Memorandum

To: Carmen Moran
CC: Nancy Cline
From: Clay Barnett
Date: 8/23/2007
Re: Beltway Office Park

FINAL PLAT
OF
VICTORIA STATION
LOT 1R

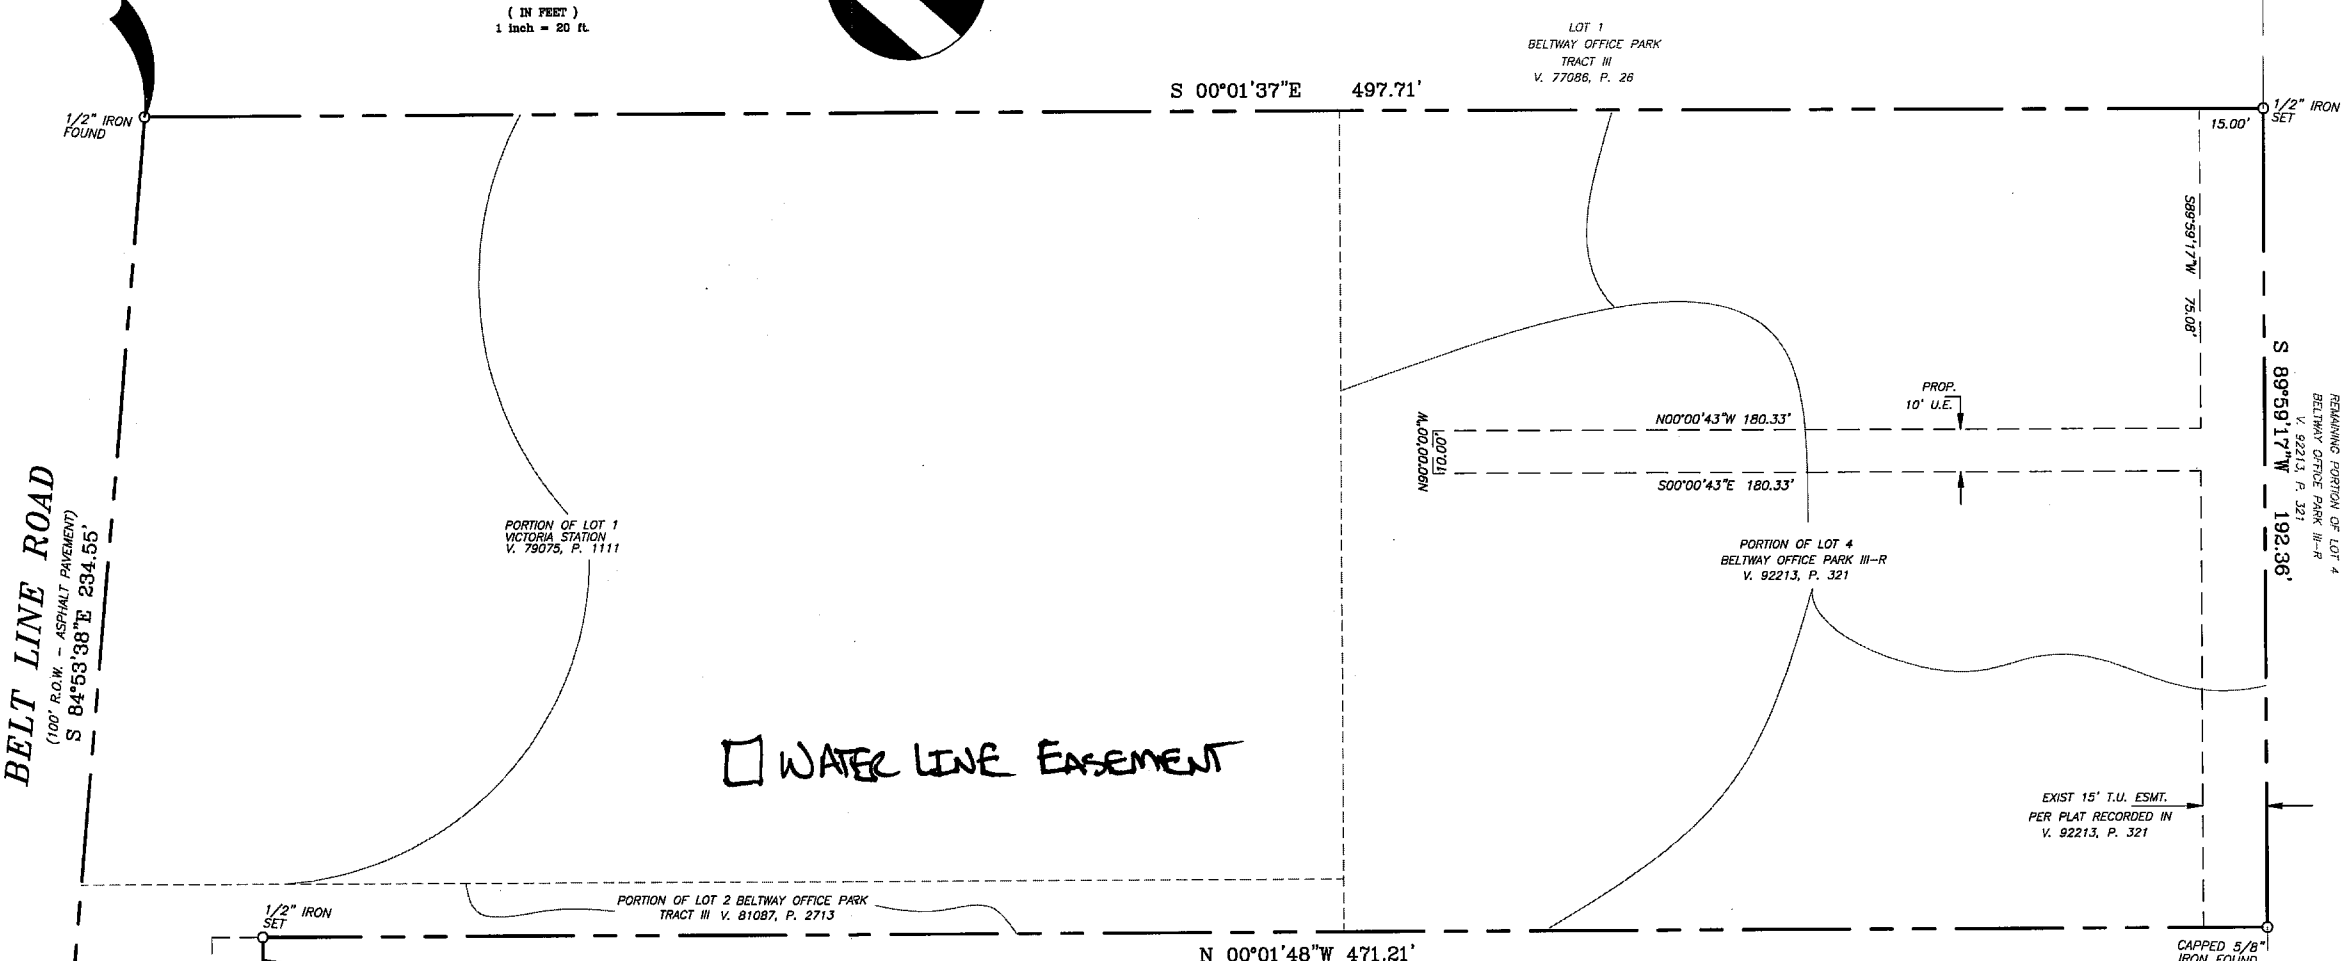
-
1. For clarity, please rename the subdivision as "Victoria Station" and label it "Lot 1R."
 2. The Dedication Statement needs to be arranged in the same order it appears in the ordinance. The signature block should follow the Dedication Statement.
 3. "OWNER'S CERTIFICATE" should be labeled at the top of the Owner's Certificate.
 4. Remove the sentence "Now, therefore, know all men by these presents:" from the Owner's Certificate (do not remove it from the Dedication Statement).
 5. The first two paragraphs in the Owner's Certificate should be combined to read "WHEREAS, OTB PARTNERS, LTD. is the owner of a 2.275 acre tract of land situated in the..."
